**2020 No. 413**

**The Millbrook Gas Fired Generating Station (Amendment)  
Order 2020**

Title:
Works Package 1C
The Infrastructure Planning (Applications: Prescribed Forms and Procedure) Regulations 2009 Regulation 5(2)(j) Document Reference: 2.6.3

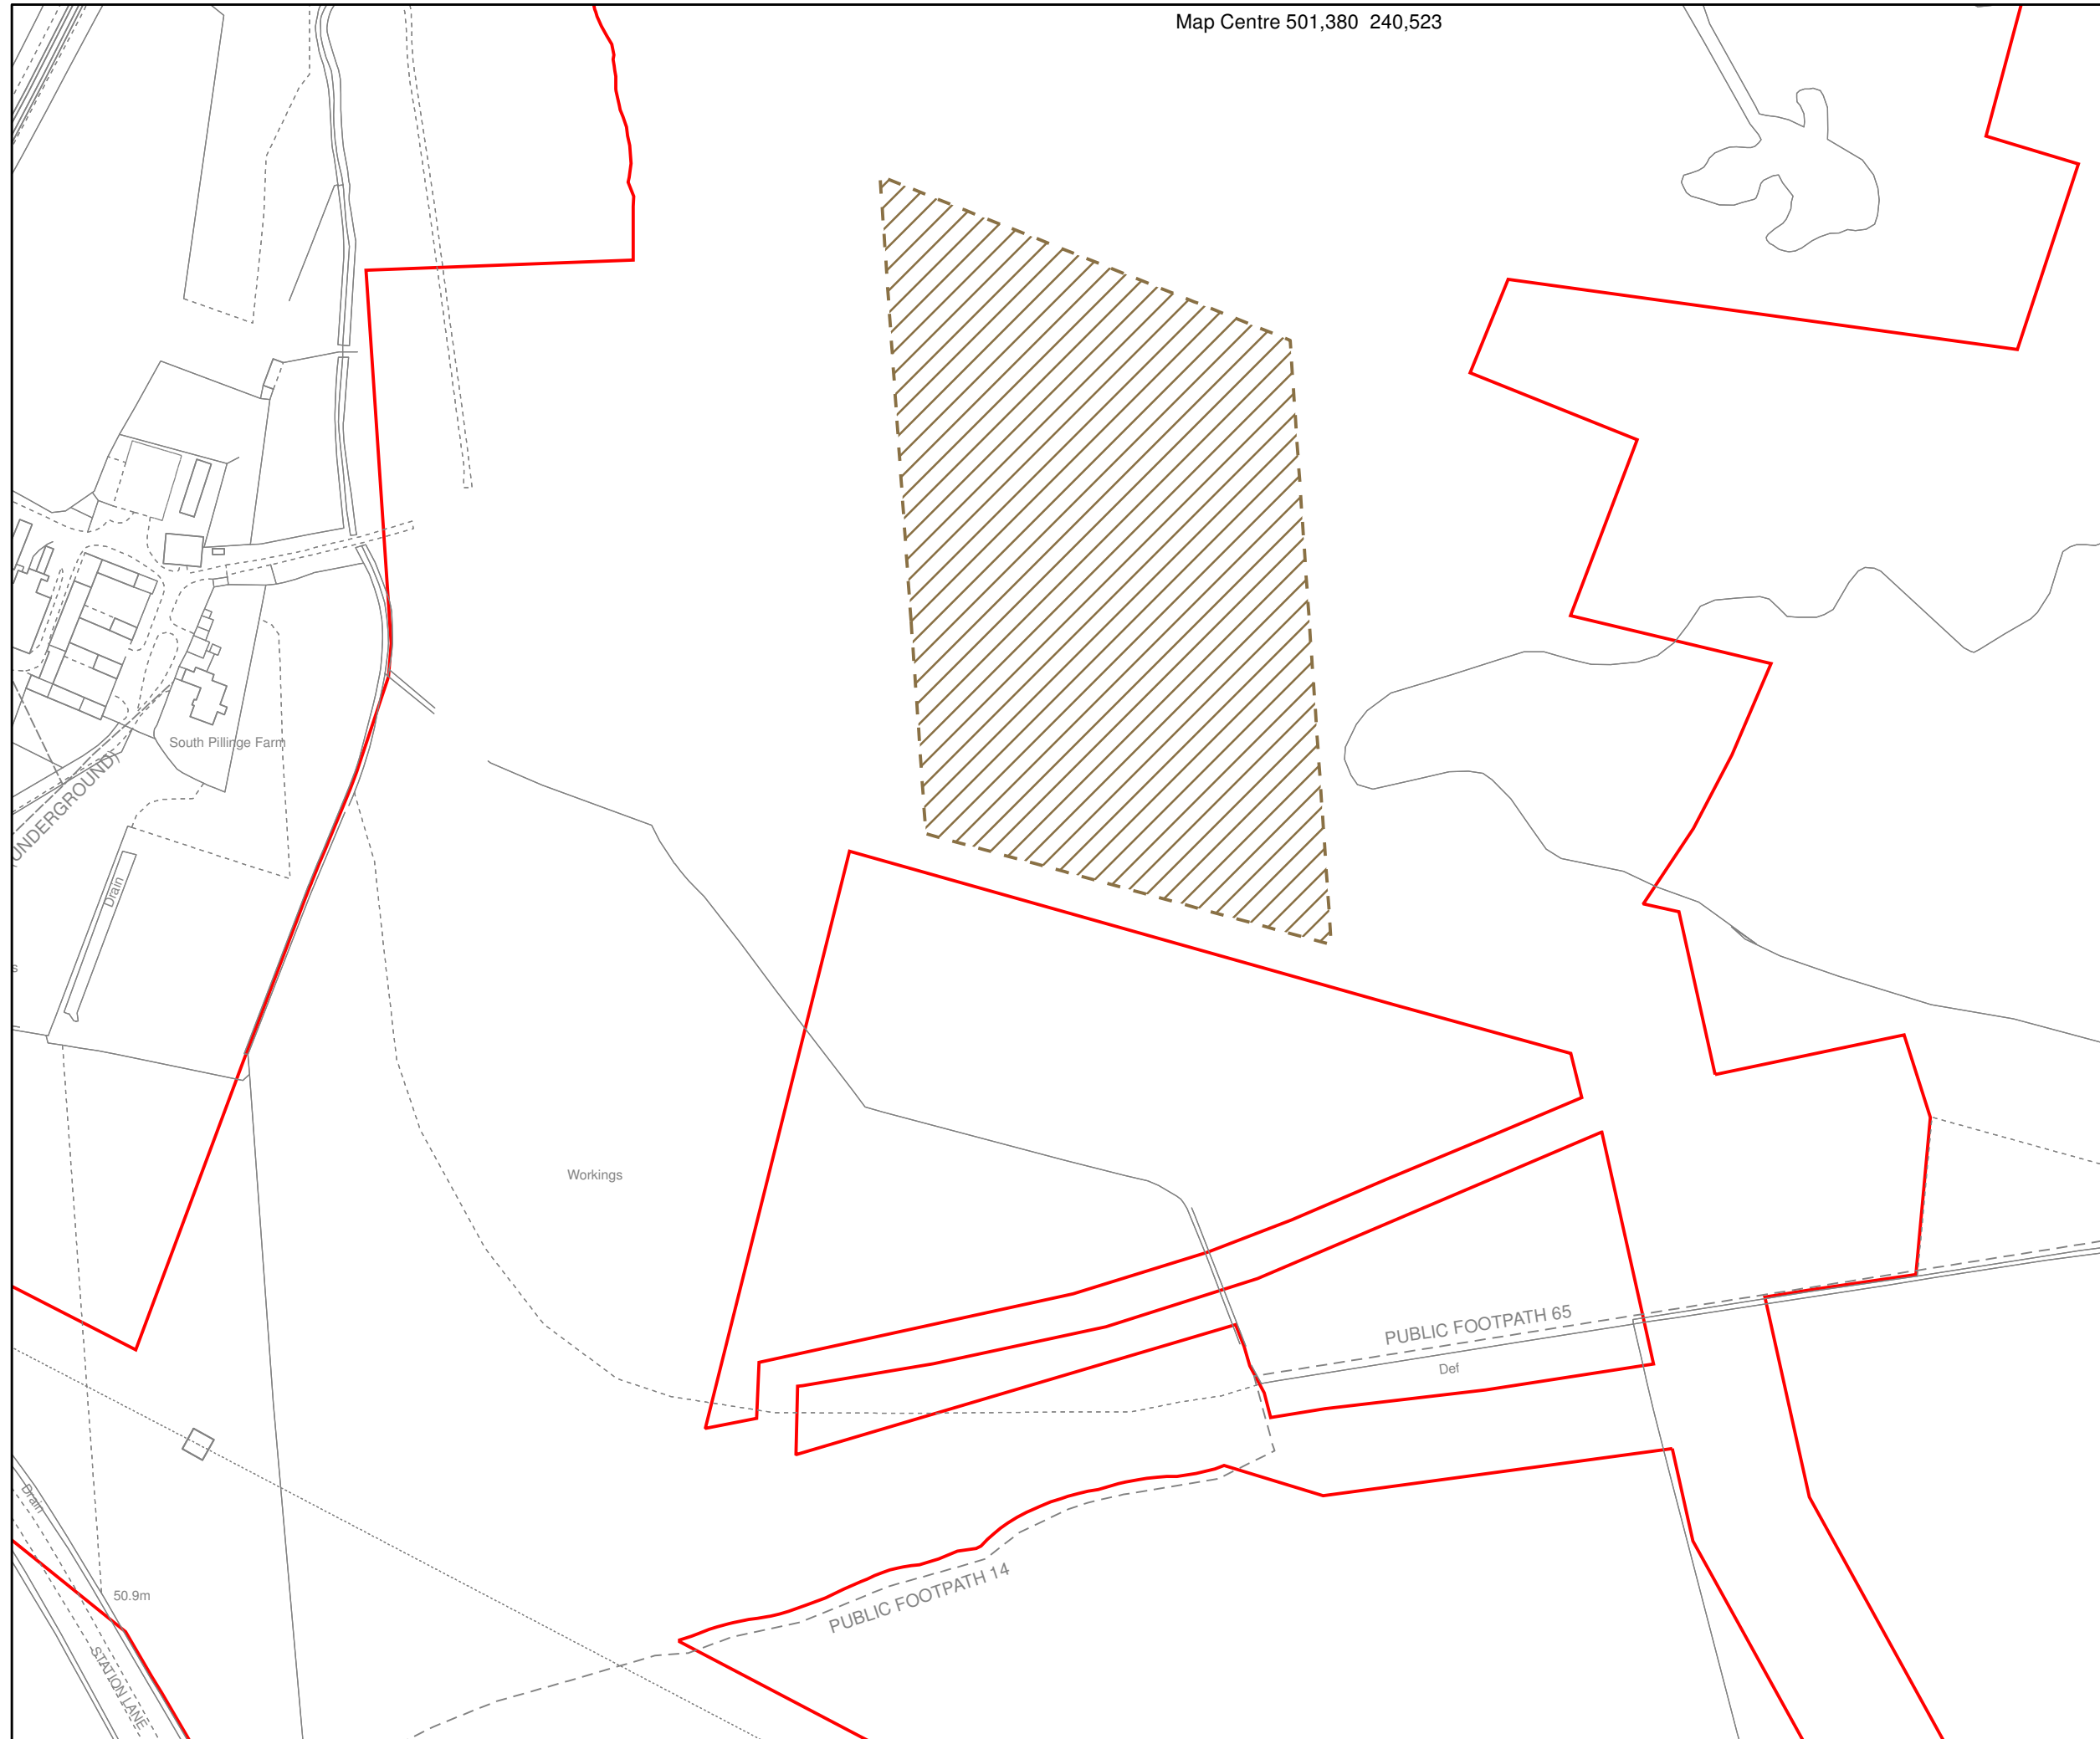
(2) In the description of numbered work 1C, omit “overhead conductor gantry,”.

Title:
Works Package 5
The Infrastructure Planning (Applications: Prescribed Forms and Procedure) Regulations 2009 Regulation 5(2)(j) Document Reference: 2.6.5

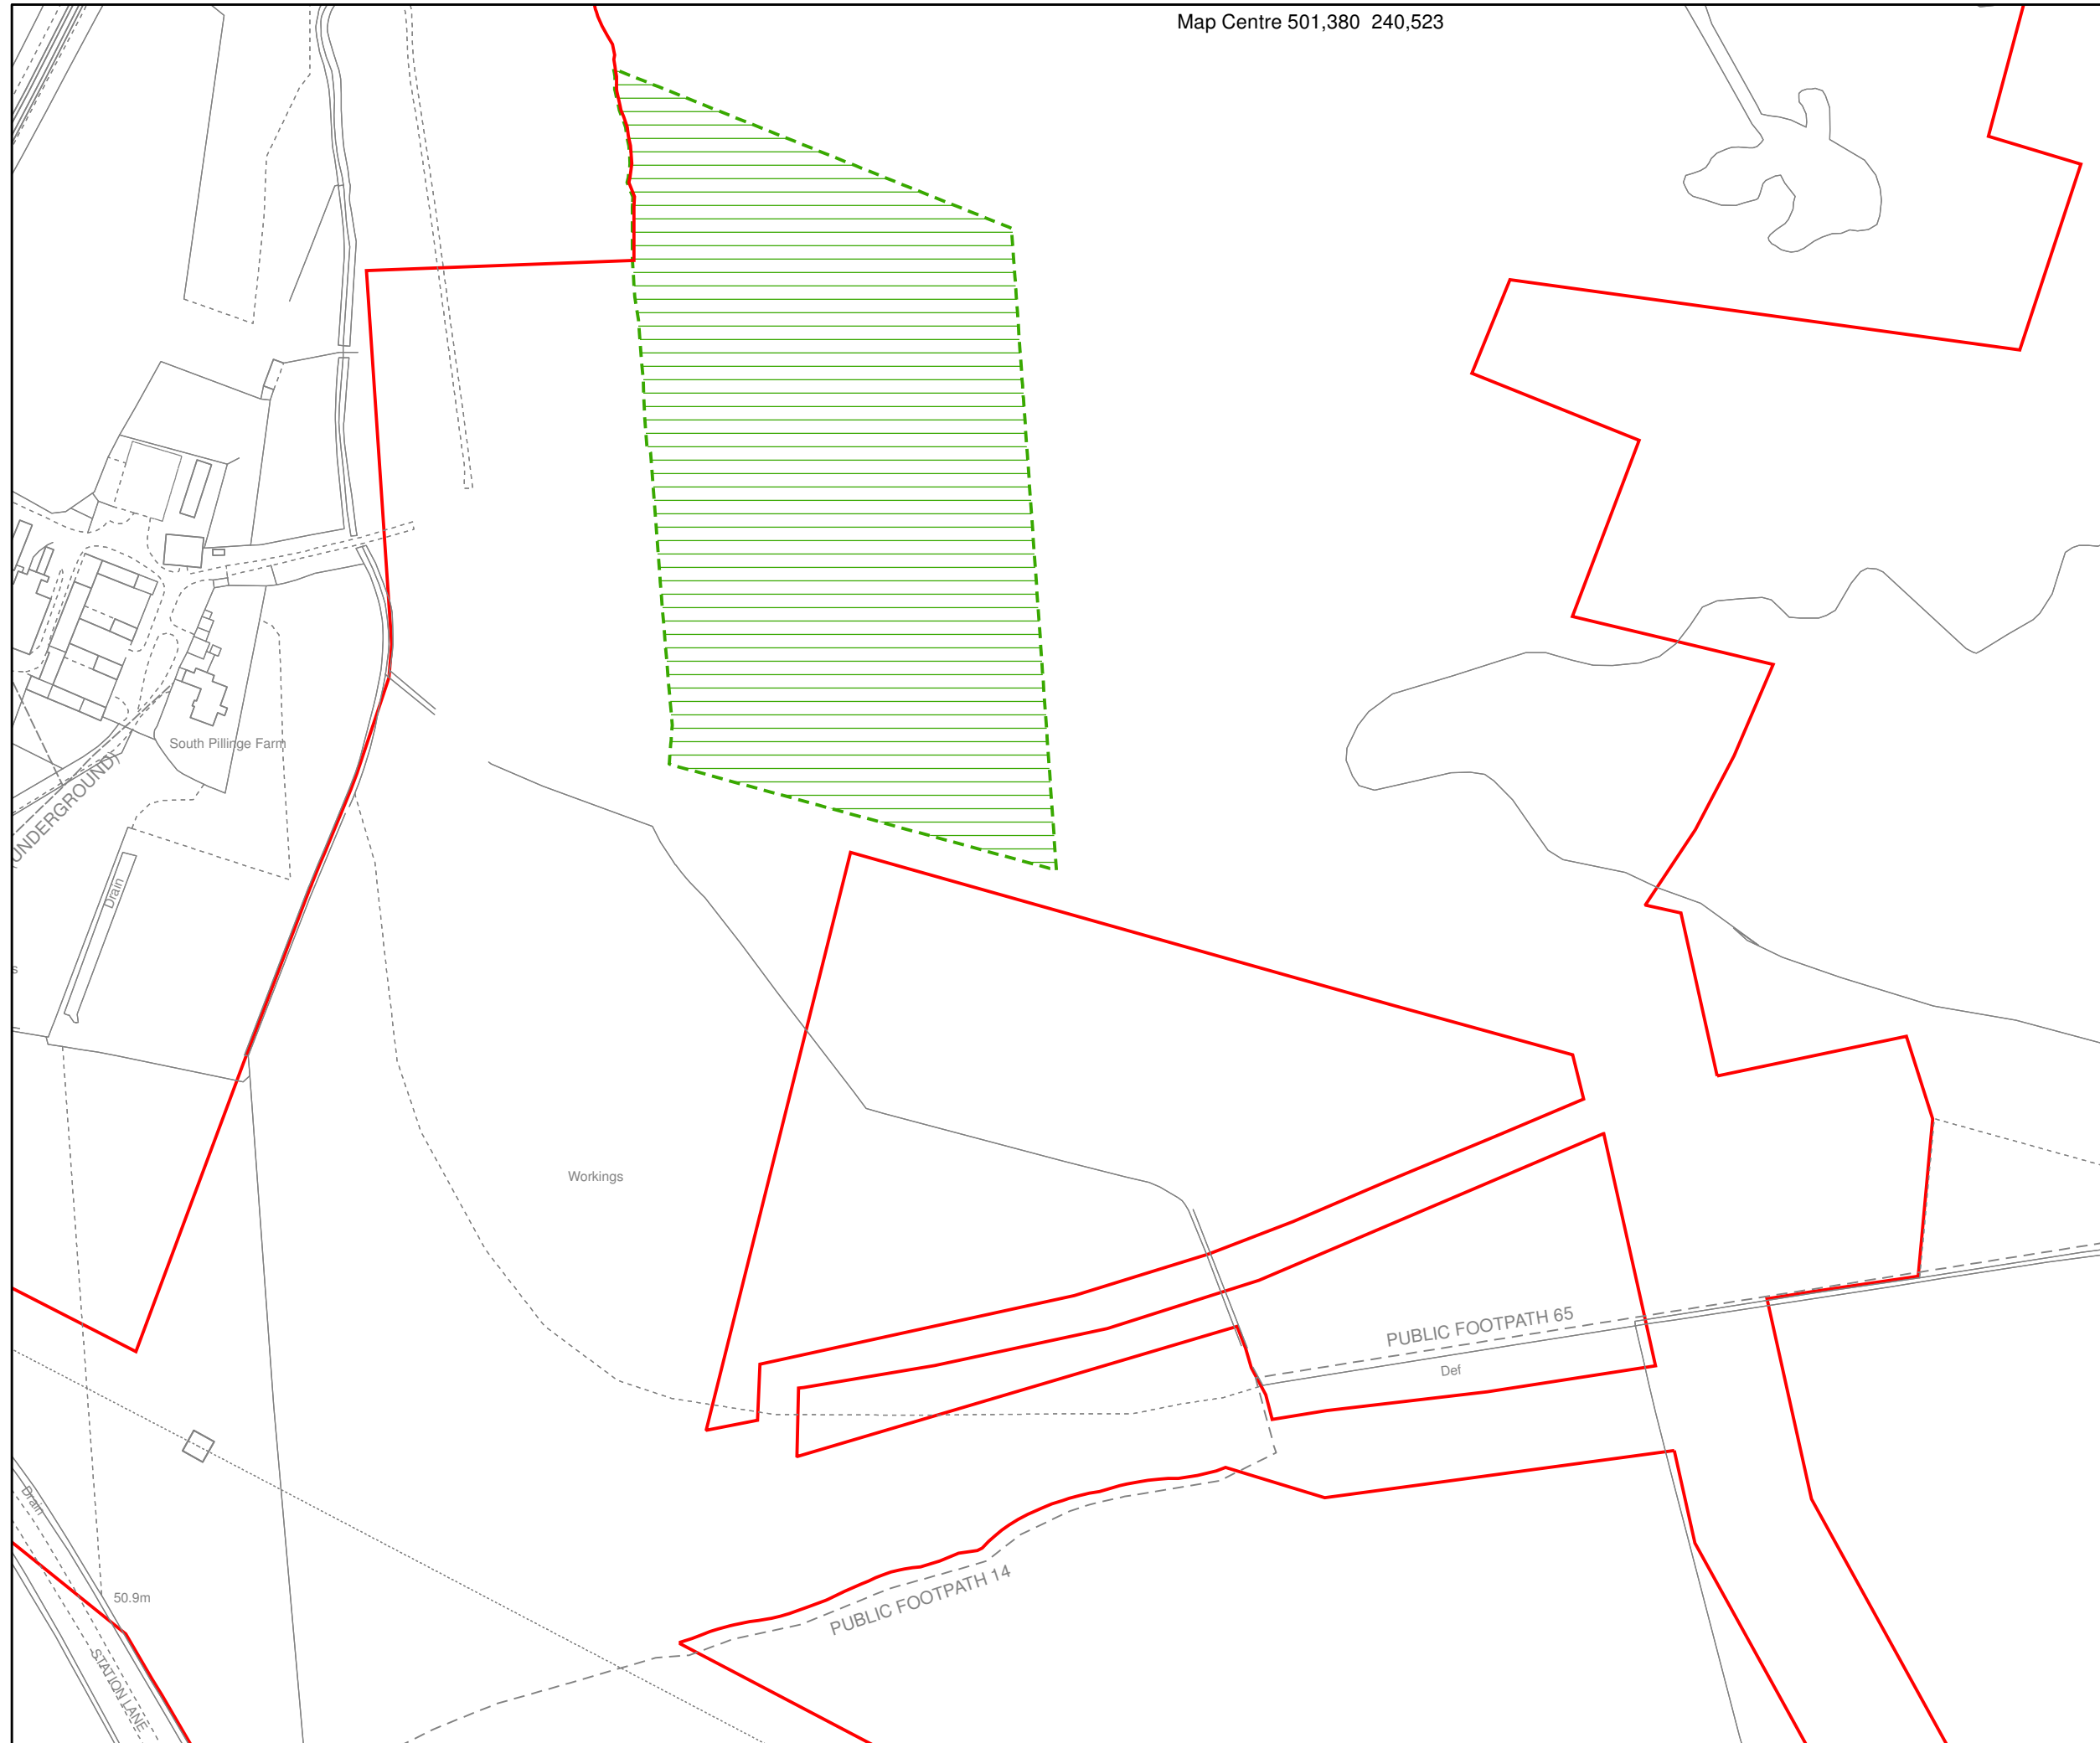
(3) In the description of numbered work 5, substitute the following paragraph—

“development comprising electrical infrastructure between Work No. 1 and Work No. 6 including—

- (a) underground high voltage electrical cables and associated telemetry and electrical protection auxiliary cabling;
- (b) landscaping including tree planting, temporary fencing and other boundary treatments and ecological mitigation; and
- (c) site drainage,”.

Title:
Works Package 6 (a, c, and g)
The Infrastructure Planning (Applications: Prescribed Forms and Procedure) Regulations 2009 Regulation 5(2)(j) Document Reference: 2.6.6

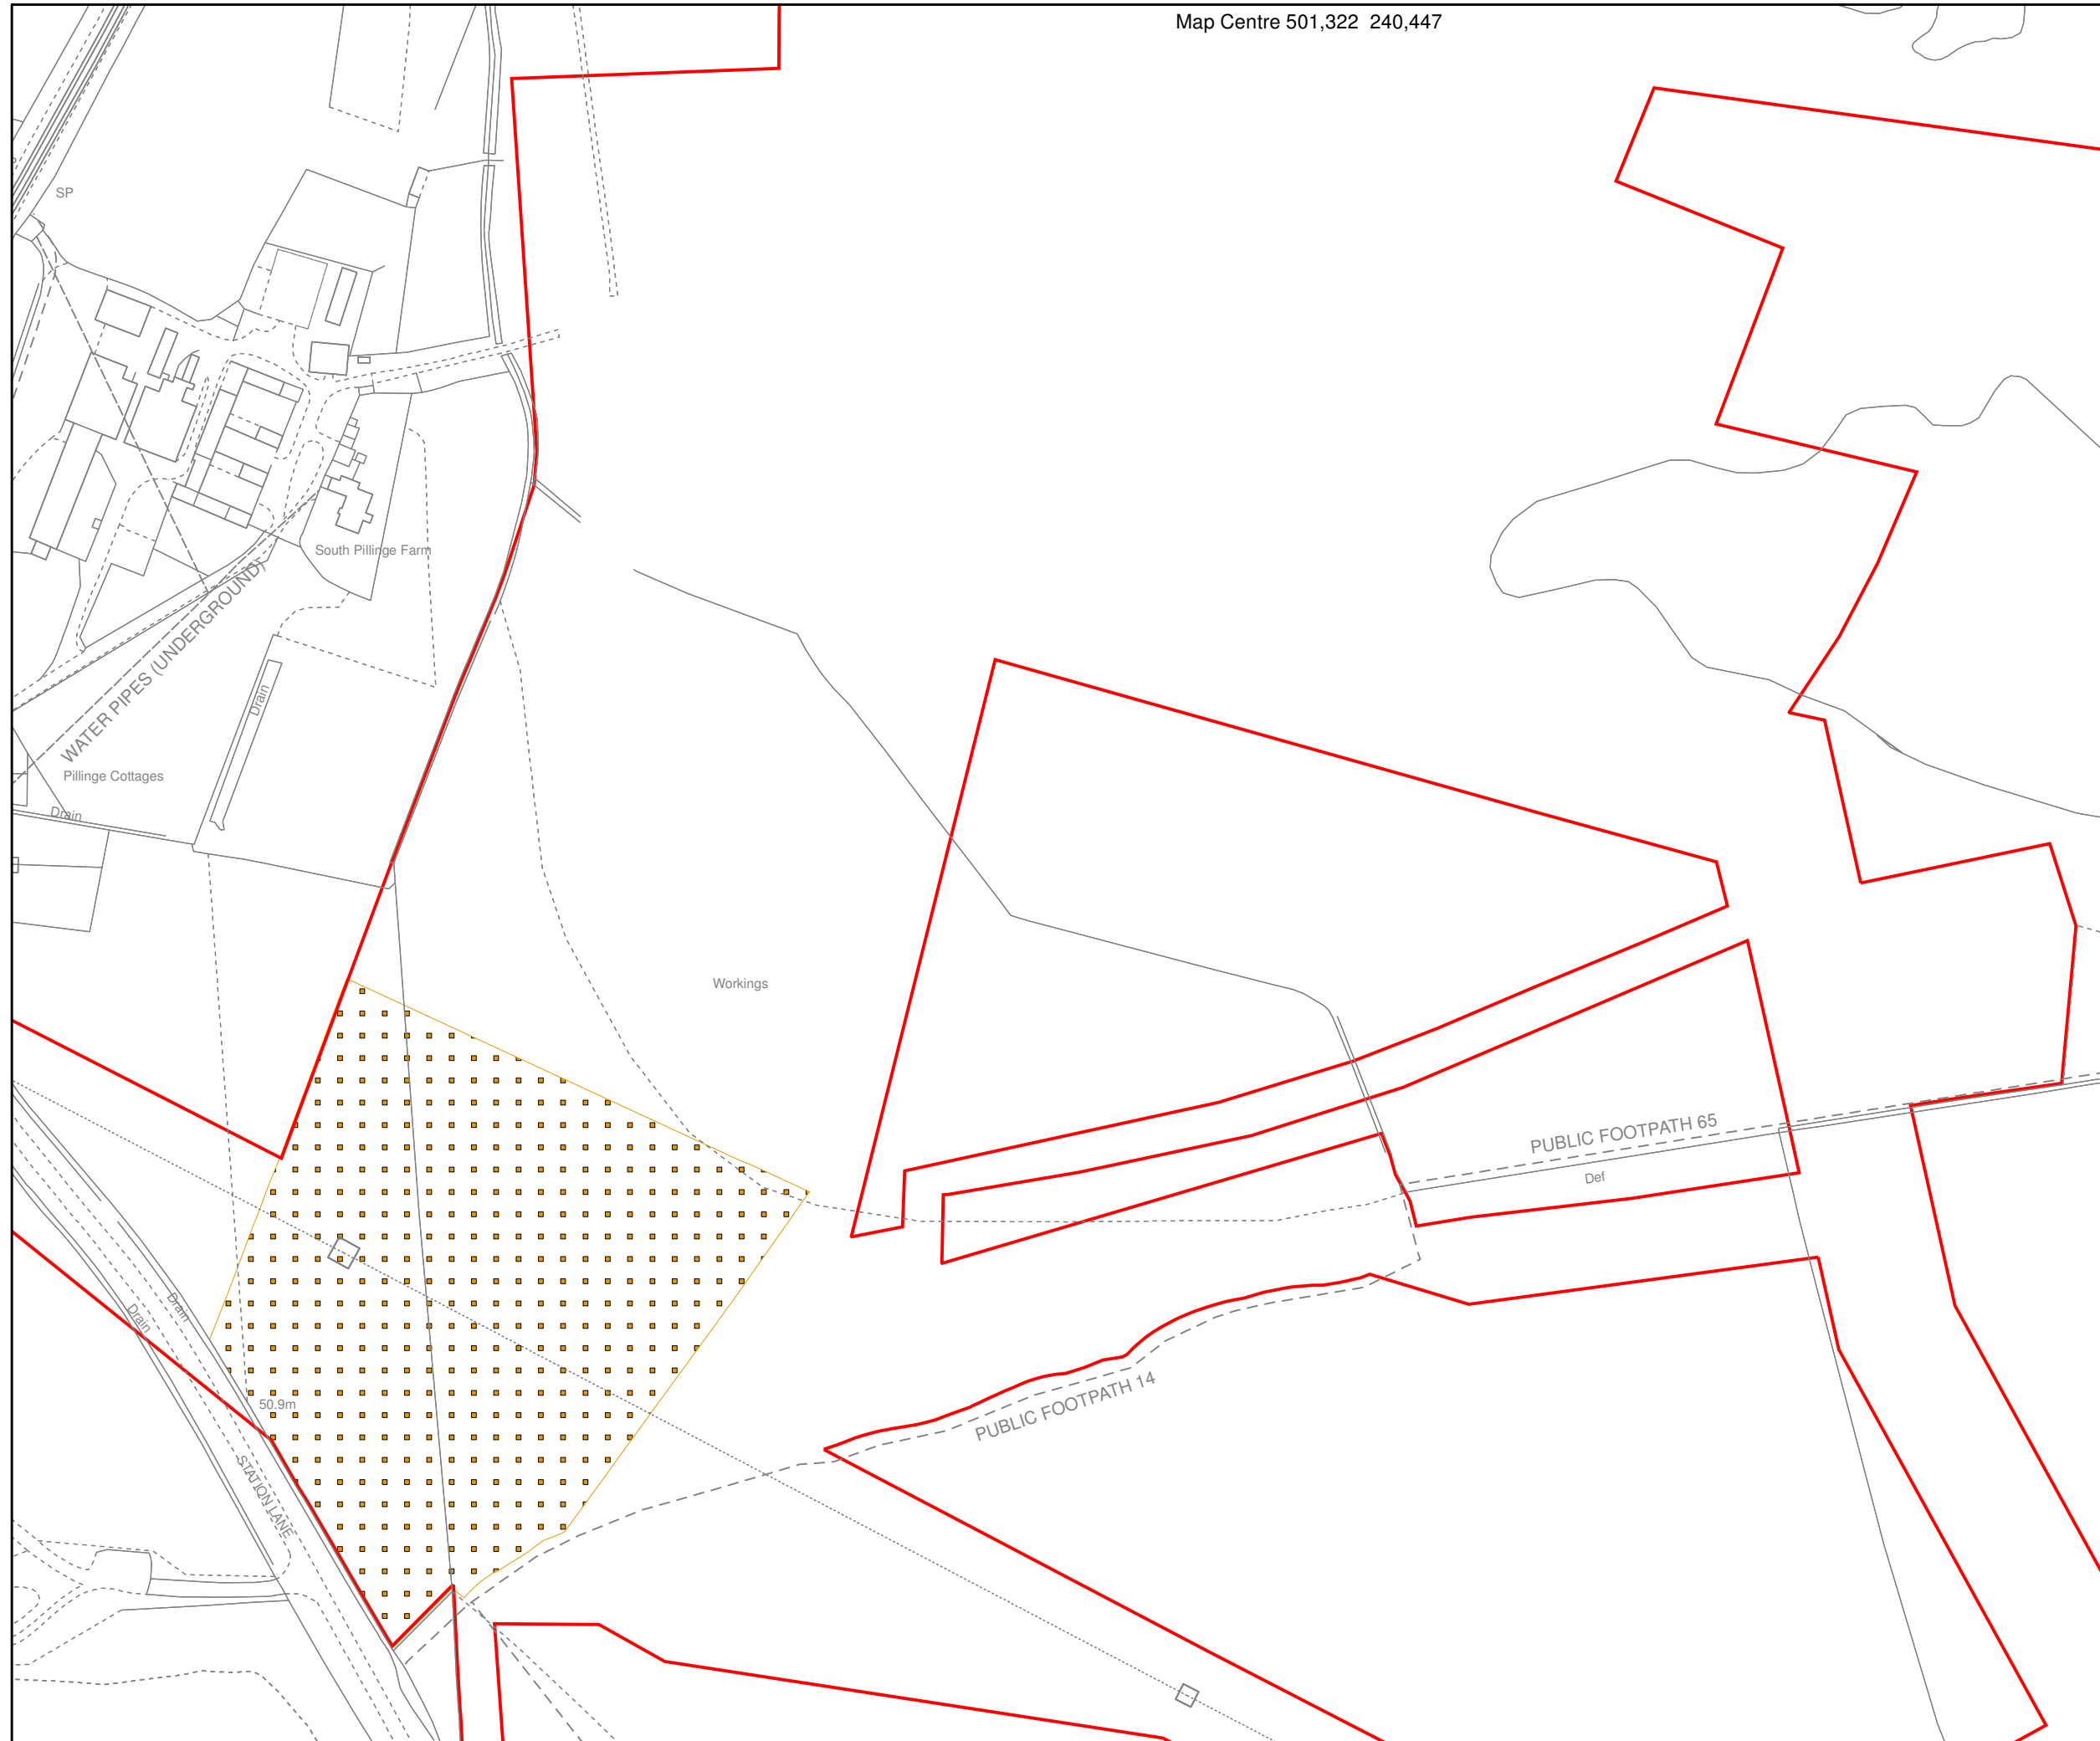
(4) In the description of numbered work 6, substitute the following paragraph—

“development comprising an electrical substation at transmission tower ZA378 and works to construct a 400kV electrical connection between transmission tower ZA378 and Work No. 5 and mitigation works for Works Nos. 1, 3, 6, and 7—

- (a) 400kV electricity substation including site office and welfare accommodation, emergency auxiliary supplies and downleads to connect to existing tower ZA378;

- (c) security infrastructure including perimeter fencing with gates, security cameras, site lighting infrastructure, including perimeter lighting columns;

- (d) permanent means of access from the low level restoration scheme secondary access to numbered work 6(a), taking the form of an agricultural hard-core track not more than 6 m wide and creation of permanent diversion of the low level restoration scheme secondary access;
